Engineers Comments Regarding Surface Water Drainage

Application No: F/17/20/DOC

Site Address: South Yard B Wicks Farm Ford Lane Ford BN18 ODF

Description of Works: Approval of details reserved by condition imposed under ref F/5/19/PL relating to Condition No 5 - surface water drainage

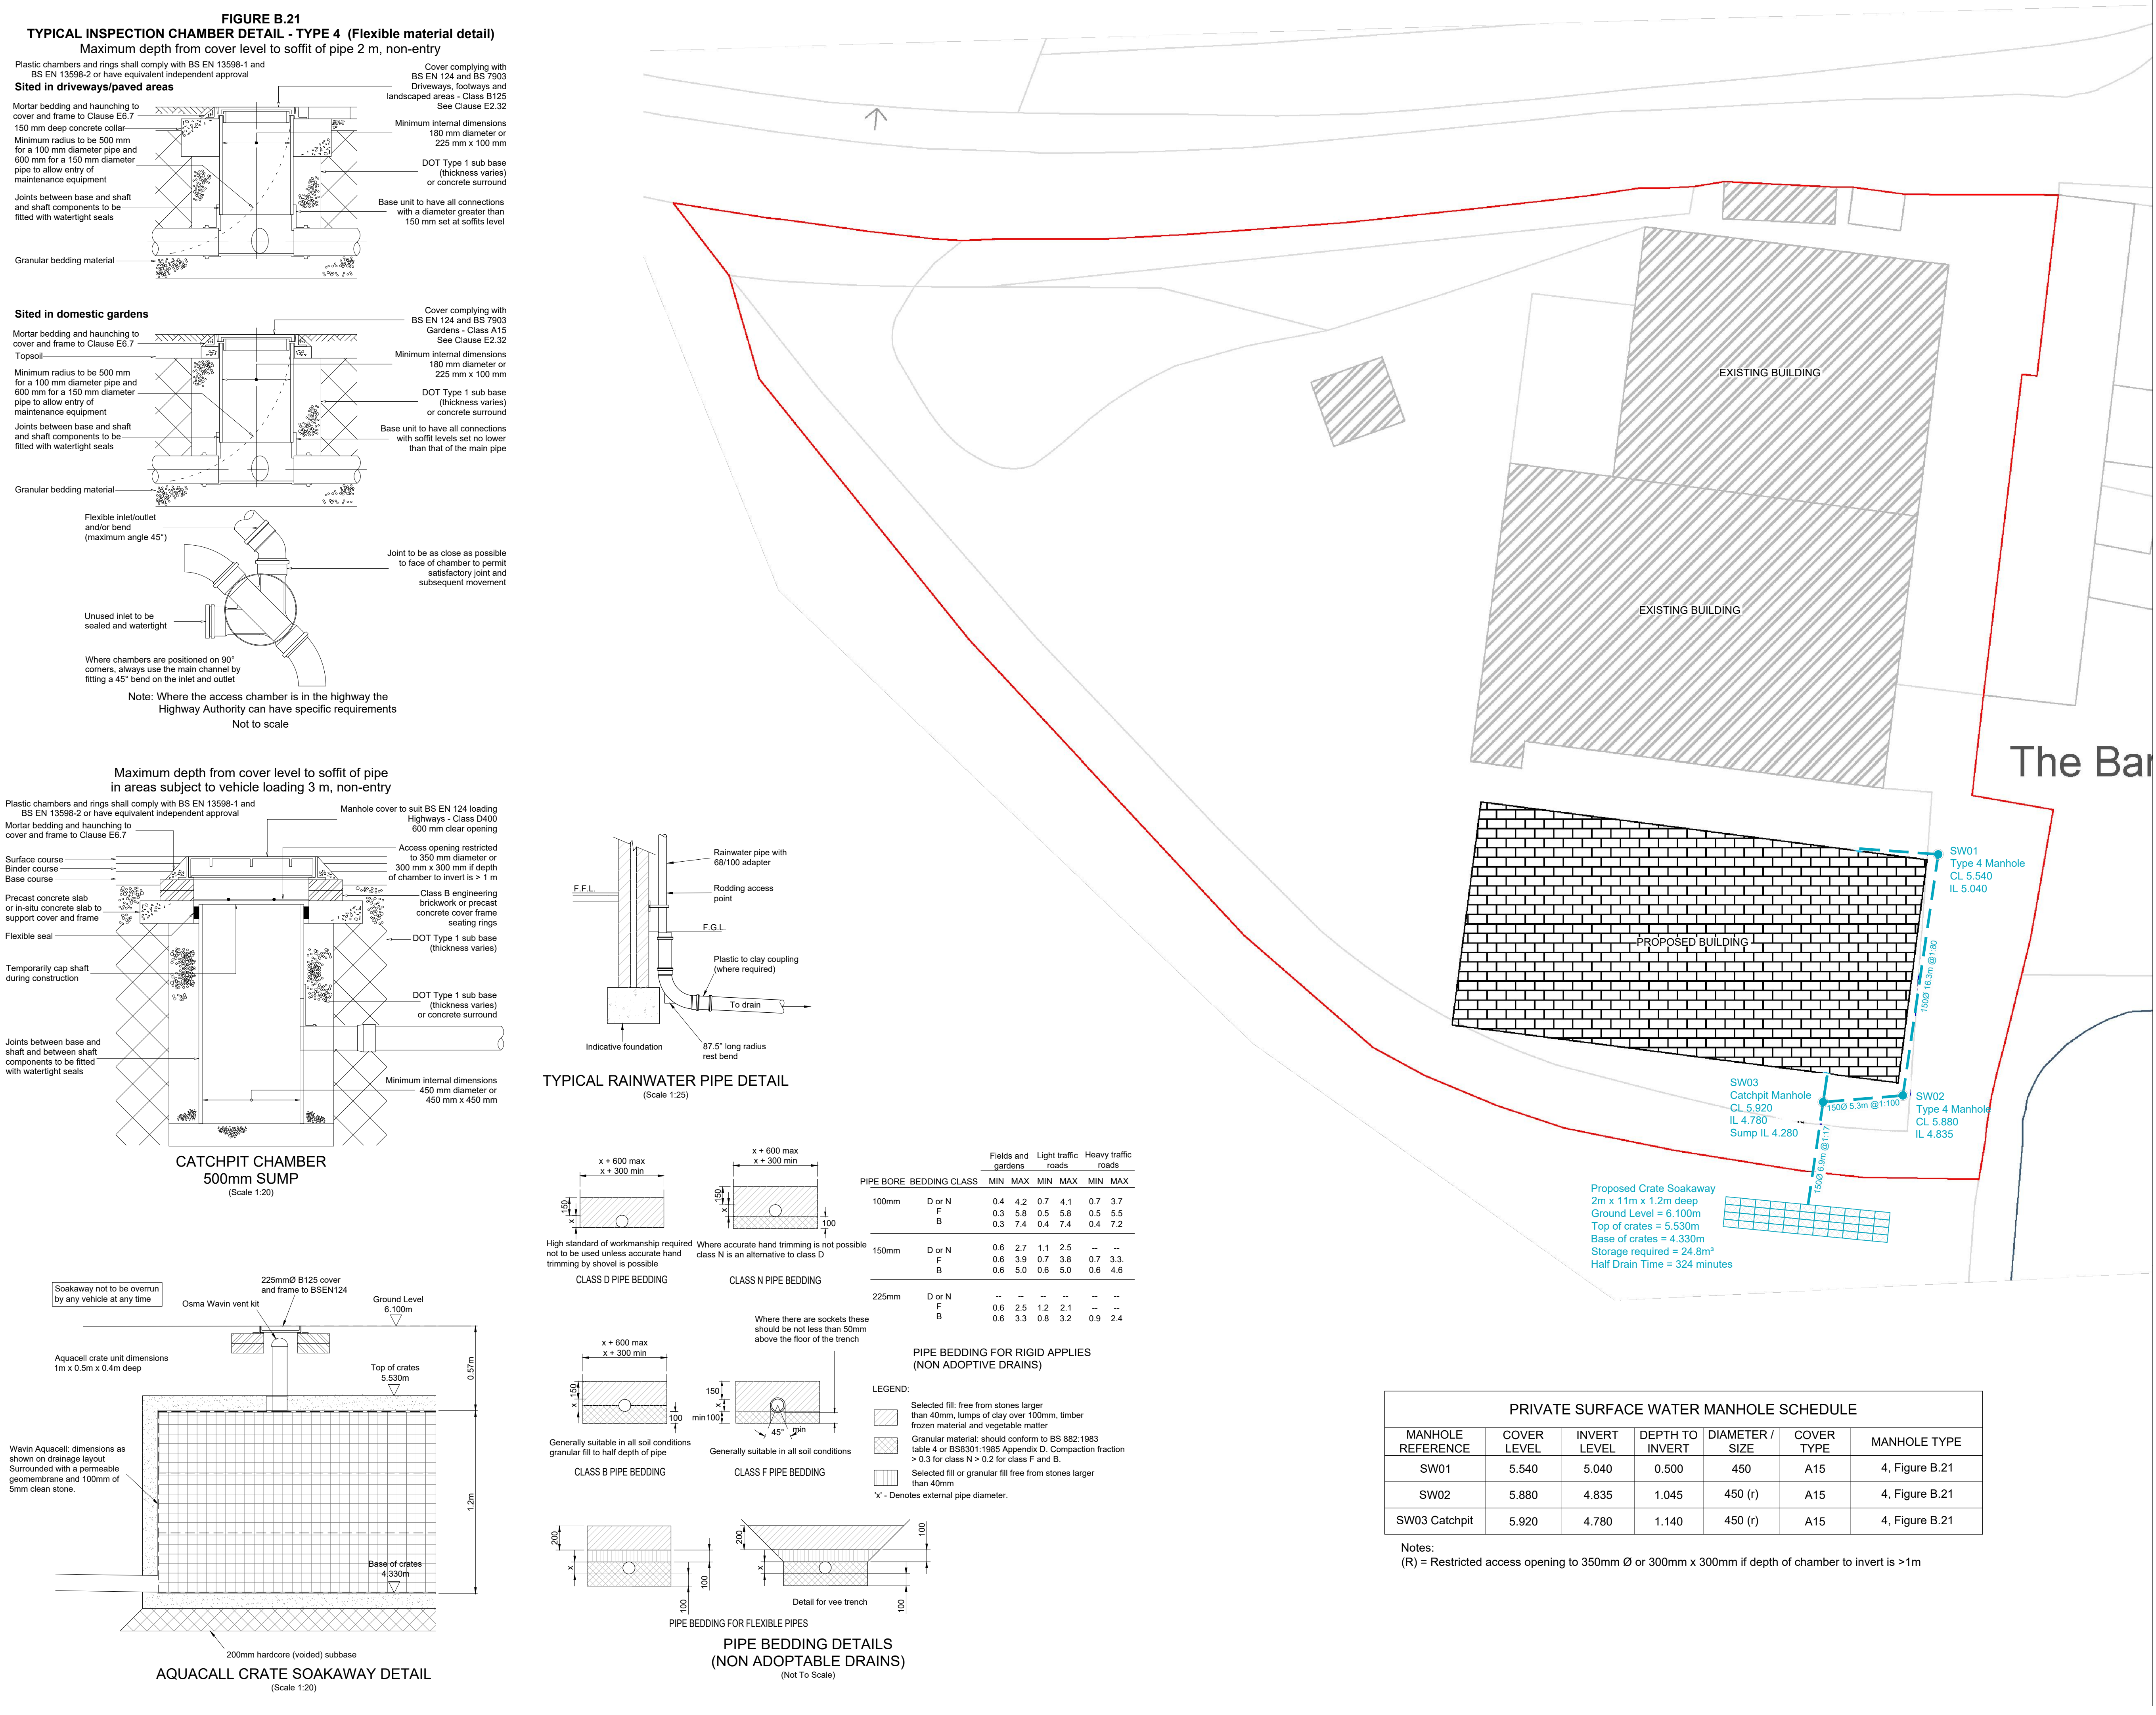
The incoming pipe to the soakaway is set at the base. Our requirements state that the 1 in 10 year storm must be catered for between the invert of the lowest entry pipe and the base of the infiltration structure. Please re set this pipe as high as possible and adjust both the invert level on the layout and the construction detail to reflect this.

I am concerned that the soakaway is shown to be in a location outside of the applicant's ownership (red line). Does the applicant have approval to be siting a soakaway outside of this site? I have checked the original application and there was no extended part of the site shown as the same ownership (blue line). If possible we would like to see the surface water drainage contained within the red line boundary for the site.
